From: Donoghue Nicholas [REDACTED]
Sent: 21 November 2019 11:12
To: Planning <Planning@arun.gov.uk>
Cc: Town Planning SE [REDACTED]
Subject: Network Rail Consultation Response: BR/243/19/PL

Thank you for consulting Network Rail about the application BR/243/19/PL. Due to the proximity of the proposed development being 1m from Network Rail land, Network Rail strongly recommends the developer contacts [REDACTED] prior to any works commencing on site, and also to agree an Asset Protection Agreement with us to enable approval of detailed works. More information can also be obtained from our website <https://www.networkrail.co.uk/running-the-railway/looking-after-the-railway/asset-protection-and-optimisation/>.

Ground Floor Plan

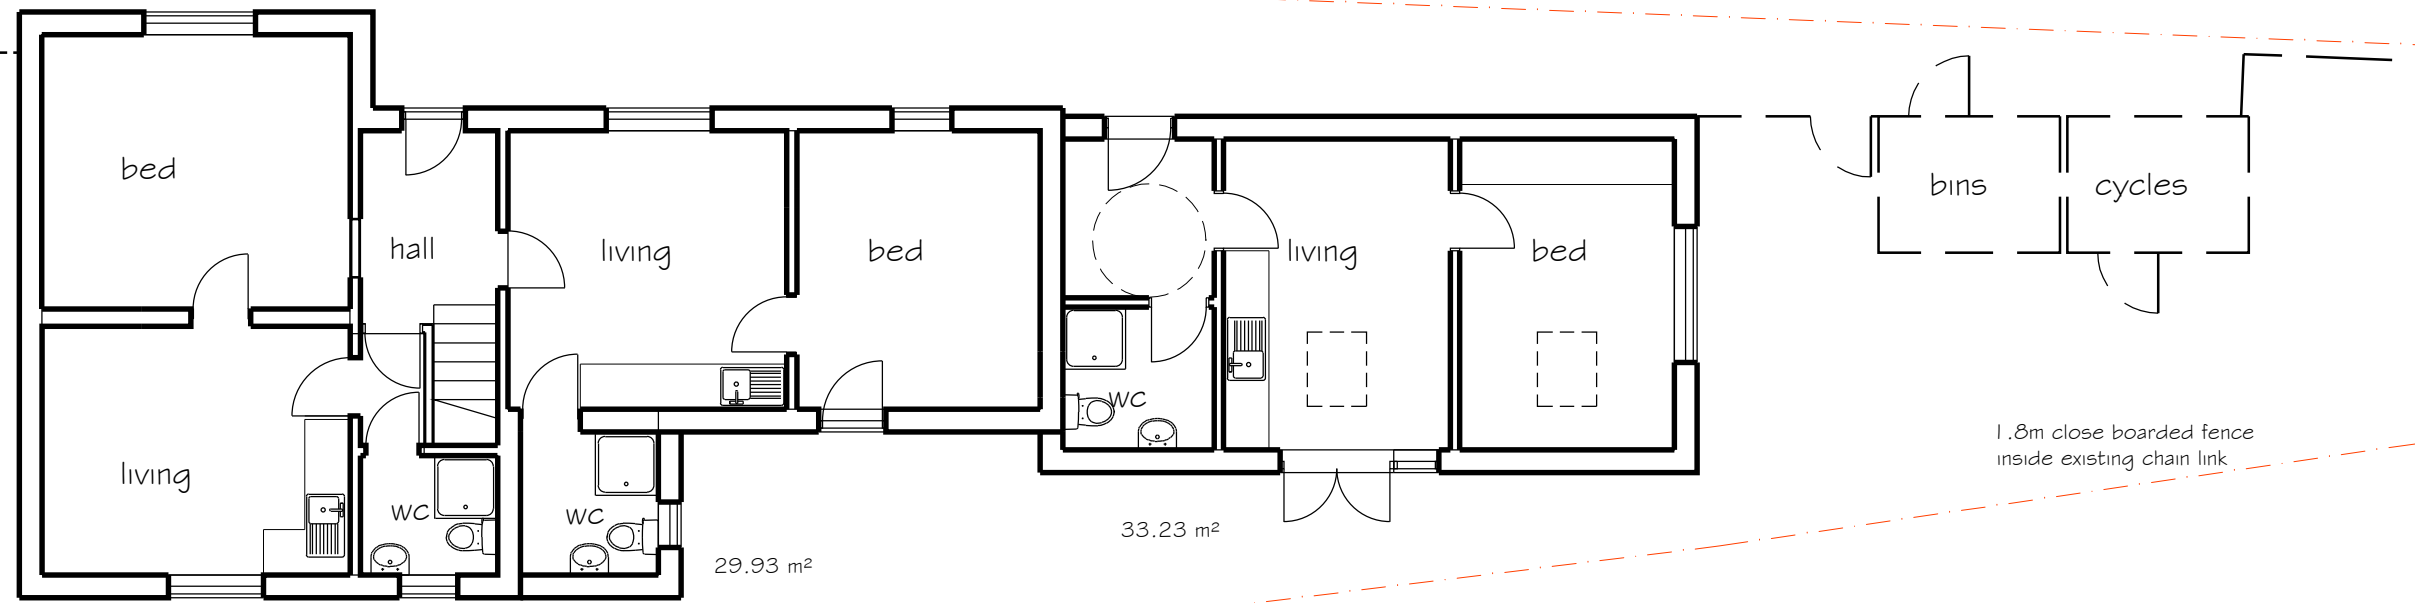
In view of the nature of the development, it is essential that the developer provide (at their own expense) and thereafter maintain a substantial, trespass proof fence along the development side of the existing boundary fence, to a minimum height of 1.8 metres. The 1.8m fencing should be adjacent to the railway boundary and the developer/applicant should make provision for its future maintenance and renewal without encroachment upon Network Rail land. Network Rail's existing fencing / wall must not be removed or damaged and at no point either during construction or after works are completed on site should the foundations of the fencing or wall or any embankment therein, be damaged, undermined or compromised in any way. Any vegetation on Network Rail land and within Network Rail's boundary must also not be disturbed. Any fencing installed by the applicant must not prevent Network Rail from maintaining its own fencing/boundary treatment.
